JR:CA:SSD5765

27 July 2020

RE: SSD 5765 ENVIRONMENTAL IMPACT STATEMENT

Thank you for providing Mid-Western Regional Council (Council) with the opportunity to provide input into the proposed Bowdens Silver Project. Council has reviewed the Environmental Impact Assessment (EIS) and wishes to provide the following comments for consideration.

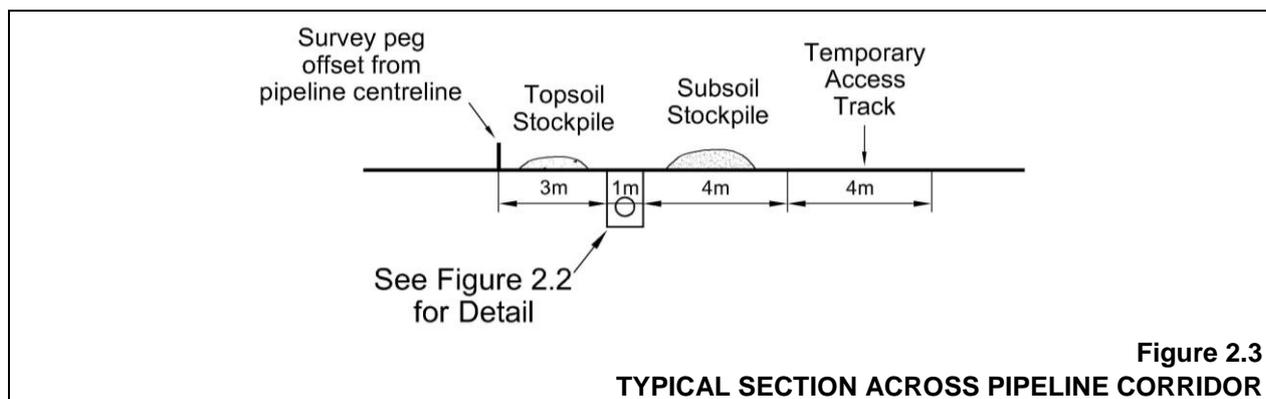
The scoping report for water supply indicates that the width of the pipeline corridor would be 12 – 15 metres wide. At this width, it would mean that the majority of any road reserve would be occupied by what is essentially a private water pipe. Further consideration of how this will impact the ability of Council to maintain its existing road infrastructure and undertake future activities within the road reserve is required. Alternatively, consideration should be given to locating the pipeline outside the road reserve as much as possible, particularly along Ulan Road.

All water supply infrastructure should be compliant with the WSAA Water Supply Code of Australia. Where the pipeline and corridor crosses any road reserve, installation must be in accordance with specifications determined by Council.

**Figure 2 Mine Site Layout**

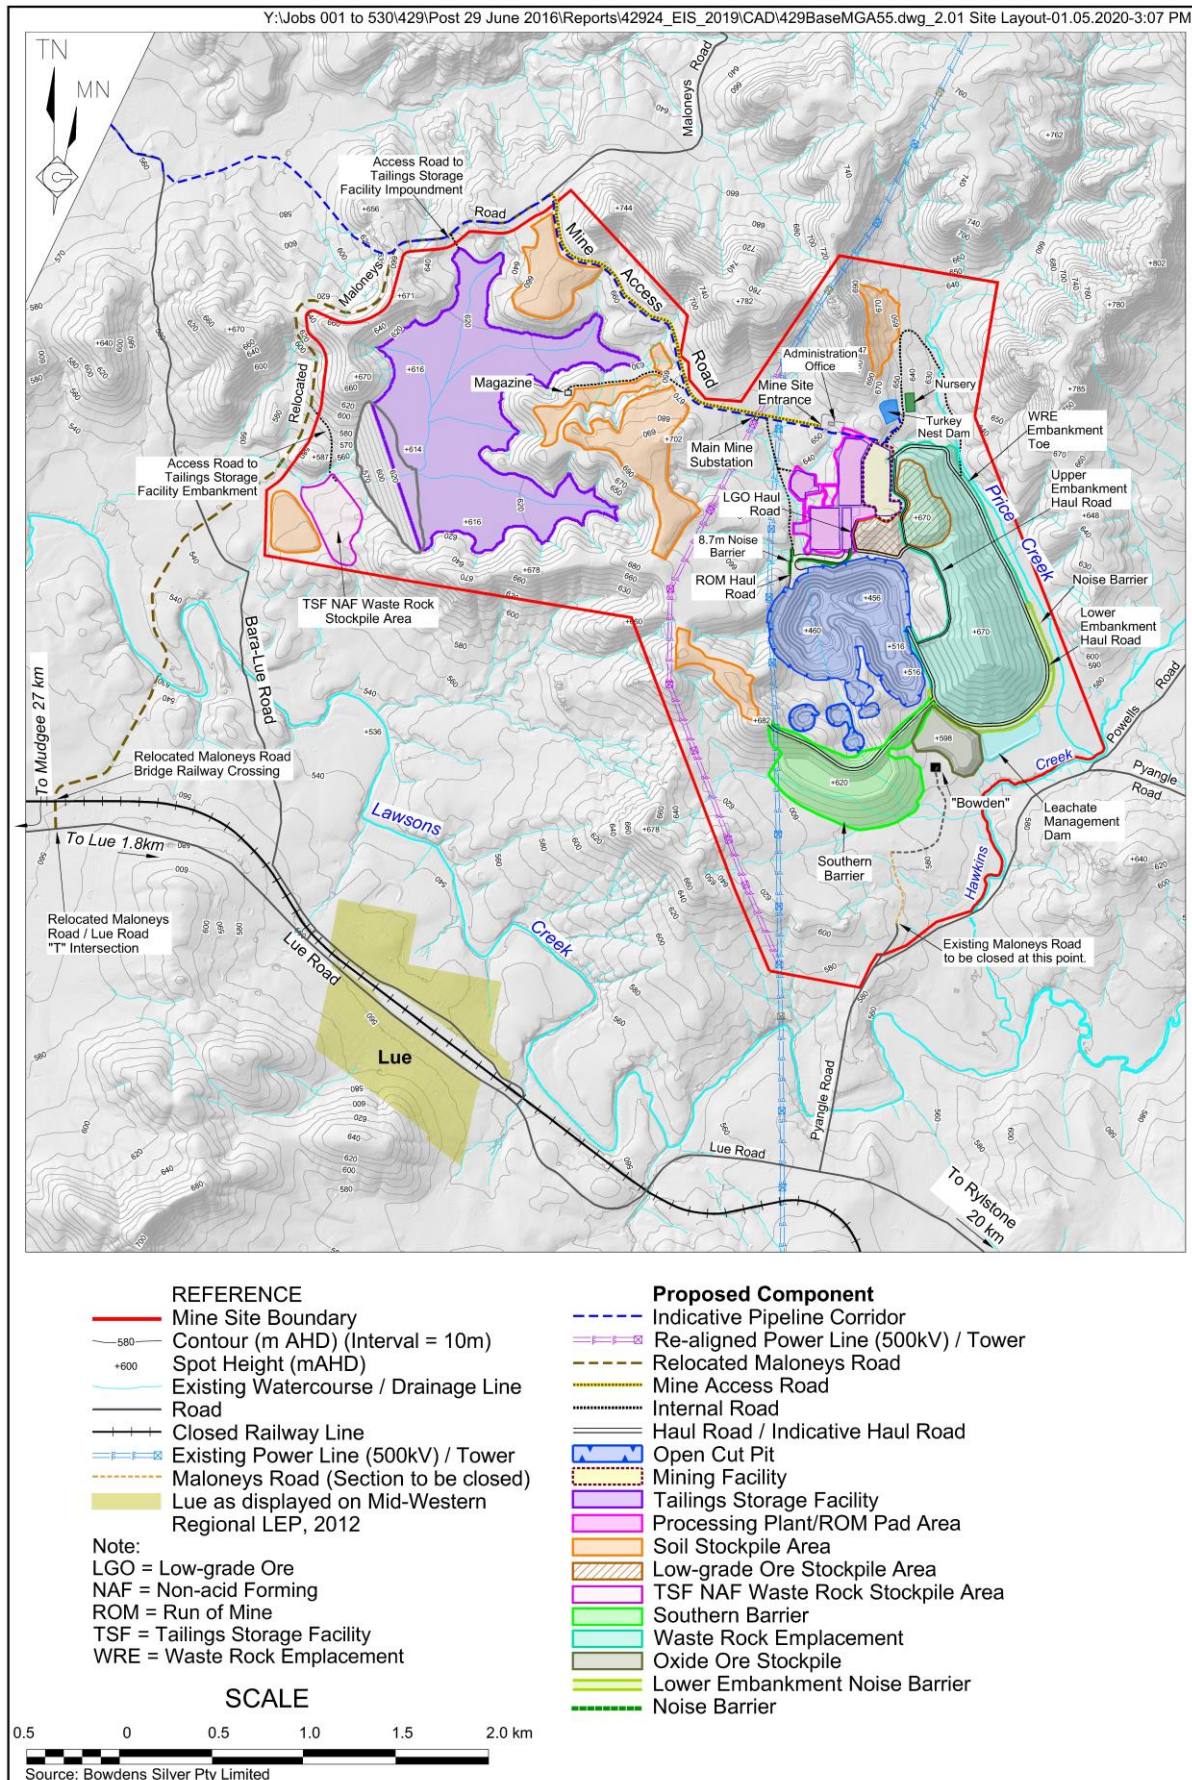
A detailed risk assessment for the construction of the tailings dam should also be undertaken. The tailings dam will contain lead, zinc and silver, as well as other chemicals used in processing, such as cyanide. If the tailings dam is not adequately constructed or there is a failure of the dam wall system, contaminated leachates entering the downstream environment would compromise the significant number of domestic and residential activities in the Region that are dependent on good quality clean water. The design and construction of the tailings dam should be independently tested under various scenarios, to eliminate the risk of a contamination incident occurring and provide multiple lines of defence should an incident occur.

As failure of the dam wall would have catastrophic consequences for the community, it is considered essential that a Disaster Management Plan be prepared and maintained to address the response to potential disasters for incidents such as failure of the tailings dam or a flood event that might cause the over-topping of the dam and result in toxic flows into the downstream environment.

Council requests that the Rehabilitation Plan sufficiently demonstrates how stockpiles of toxic waste material will be maintained over the long term, and indicates the safeguards that will be in place in perpetuity to ensure that no acid forming material leachates into the Lawsons Creek. The Rehabilitation Plan must also specifically address decontamination of the proposed tailing dam, which is located in an upper catchment from which runoff directly feeds into Lawsons Creek.
